**Consultation Response from KC,
Highways Development Management****2026/90938 land at, Hanging Stone Road, Berry Brow, Huddersfield, HD4 7QU****Erection of detached dwelling (within the curtilage of a Listed Building)****Date Responded: 7 May 2026****Responding Officer: Sheila Henley****Responding Ref: 3-50/35****Recommendation: No objection subject to conditions**

Ref to Drawings: 1476-GGD-DR-PL-1001 Proposed Site / Block Layout; 90-003 – ACCESS; ATTP 25021/VIS/003 Visibility Splays; and ATTP 25021/SPA/001 Rev B Swept Path Analysis.

-  2.4 x 28m JUNCTION VISIBILITY SPLAY IN ACCORDANCE WITH MANUAL FOR STREETS (22mph DESIGN SPEED)
-  RETAINING WALL REALIGNMENT REQUIRED TO ACCOMMODATE VISIBILITY SPLAY

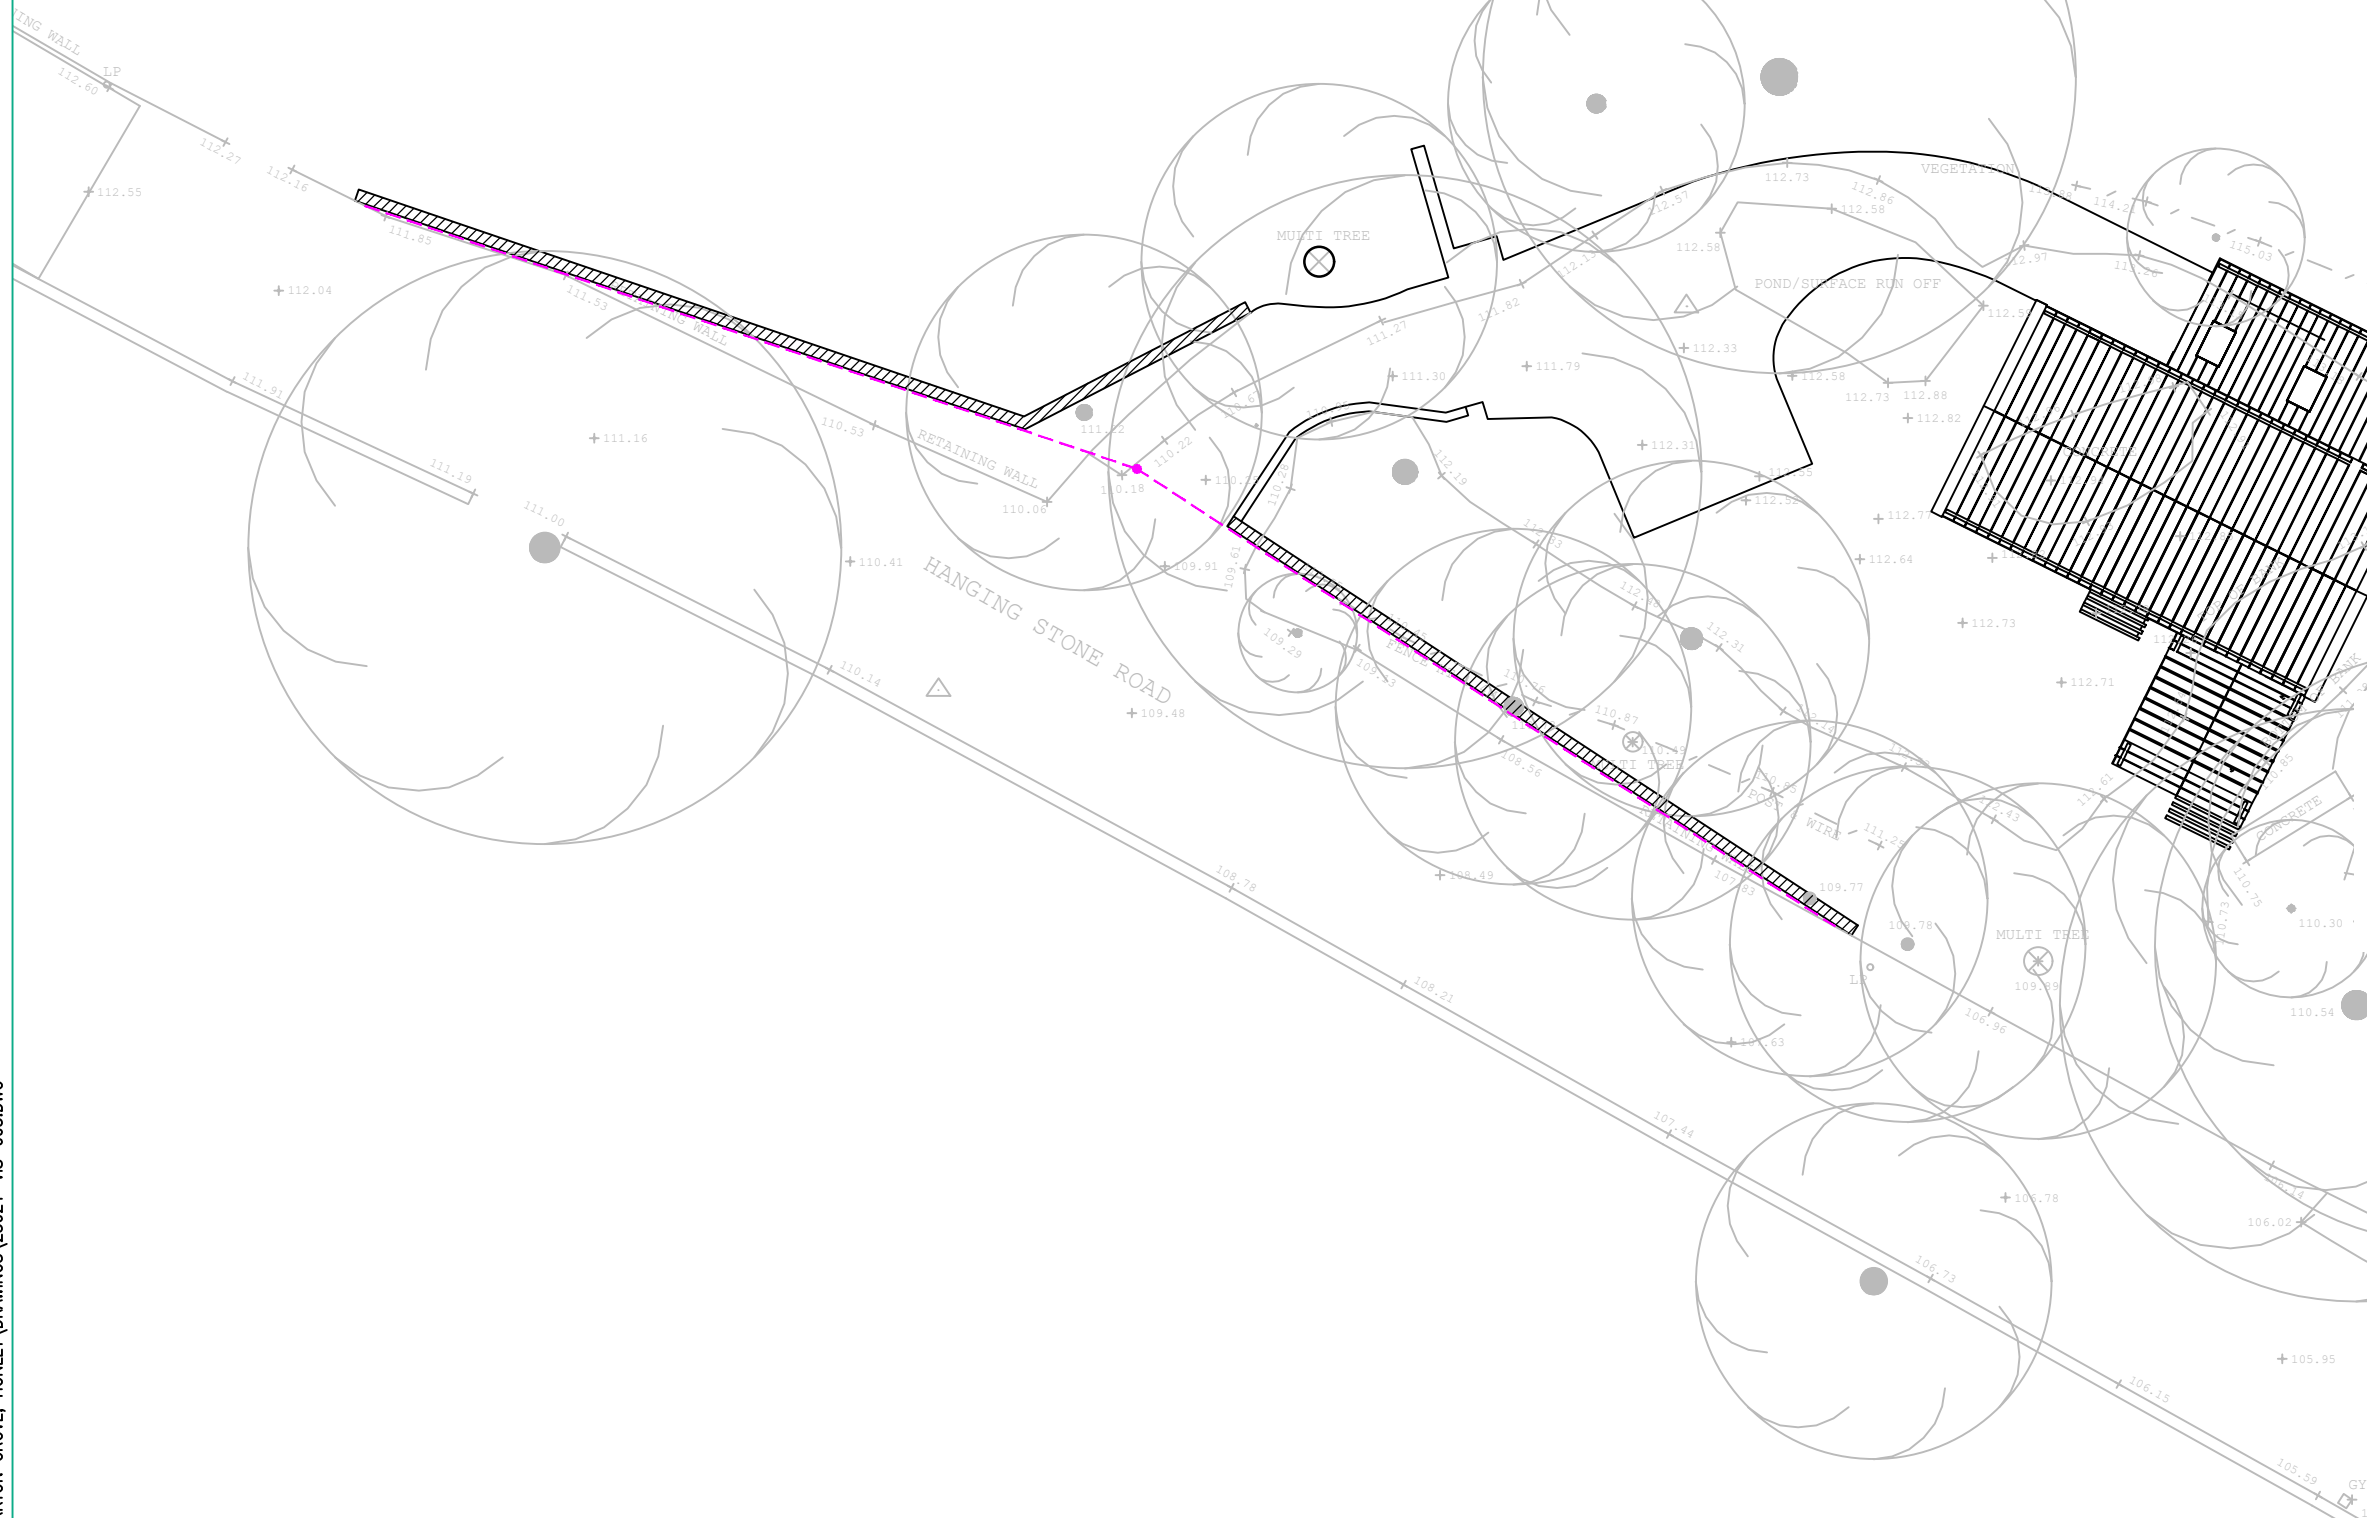
The boundary set back would provide greater visibility on exit in each direction and confirmed within the submitted Highways Note at Appendix C, Drawing 25021/VIS/003.

Visibility splays on exit are based on a November 2025 survey of speeds along Hanging Stone Road in the vicinity of the site access rather than those for a 30mph speed limit given the road is subject to speed reducing measures. The subsequent calculation derived 85th percentile wet weather speeds of 21.79mph for vehicles travelling northwest bound and 22.49mph for vehicle travelling southeast bound equivalent to a requirement for 2.4m x 28m visibility splays at the site access, in both directions. The splays are acceptable and less than the 2.4 x 43m required in each direction for a 30mph speed limit.

D:\ONEDRIVE\ATTP\25021 - PARKTON GROVE, HONLEY\DRAWINGS\25021-SPA-001.DWG

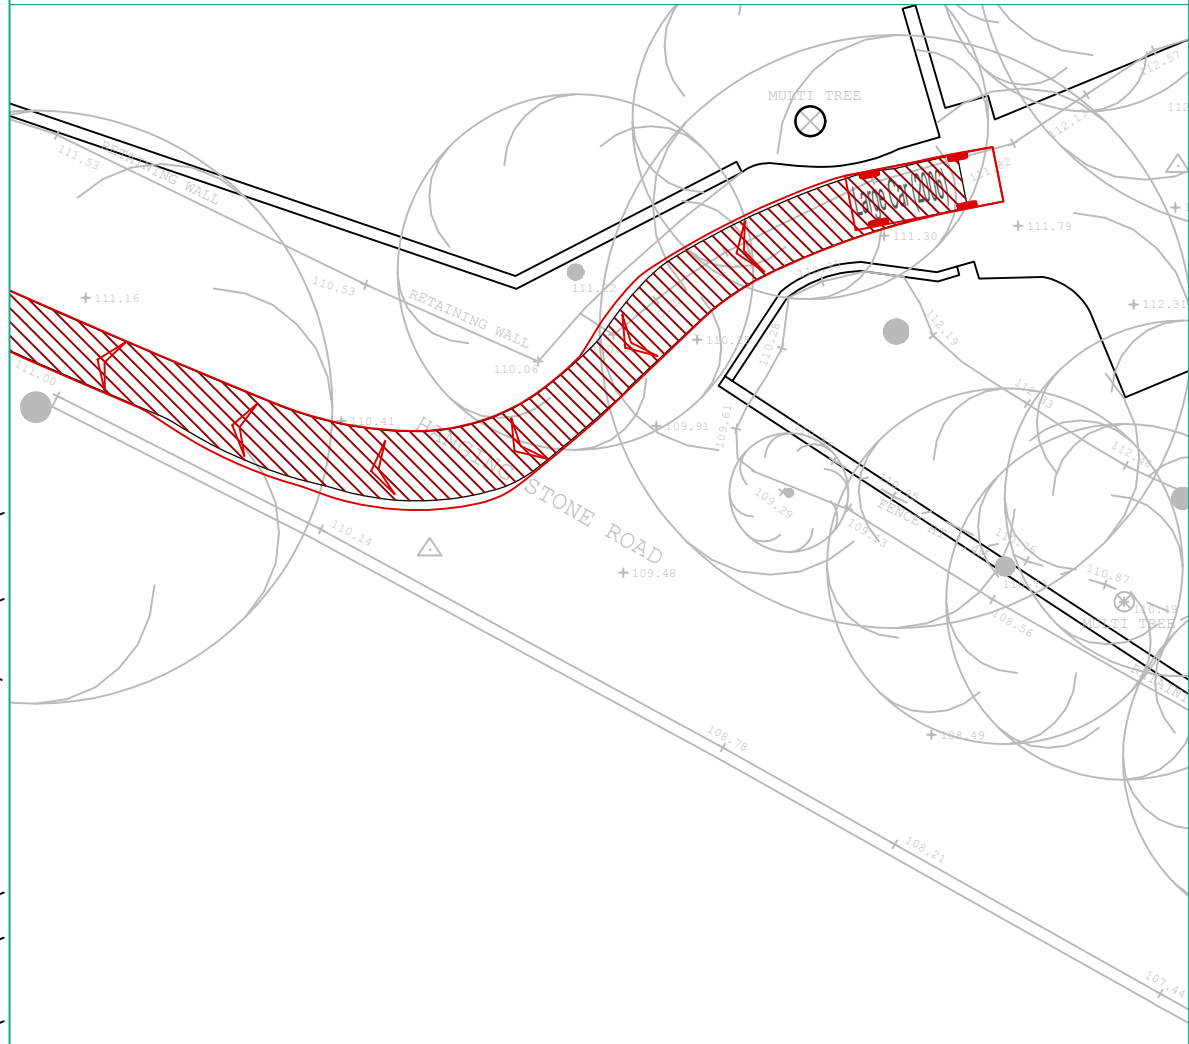
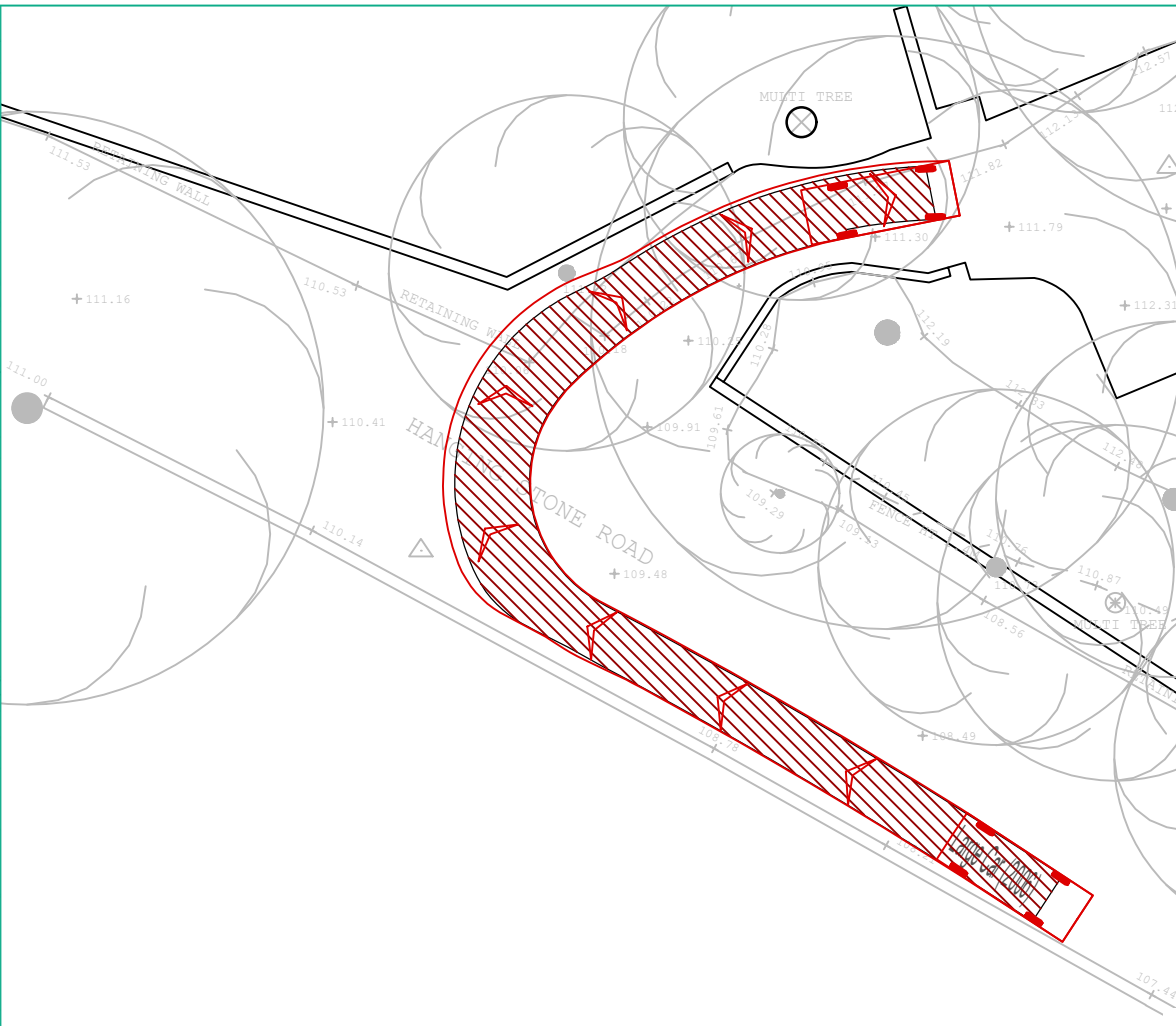
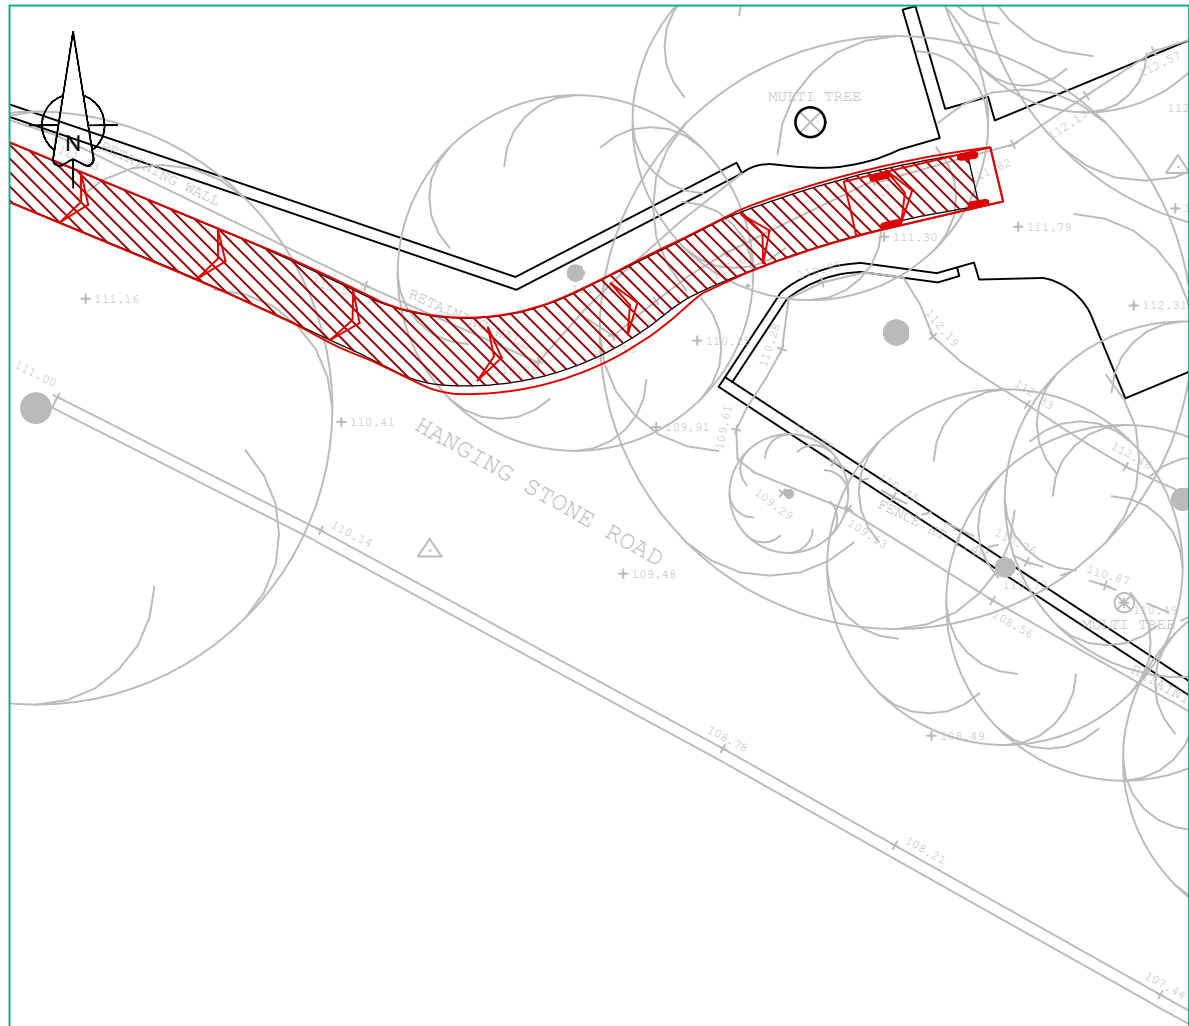
Satisfactory forward gear entry and exit is illustrated by a swept path analysis for a large car on Drawing 25021/SPA/001 Rev B at Appendix D of the Highways Note.
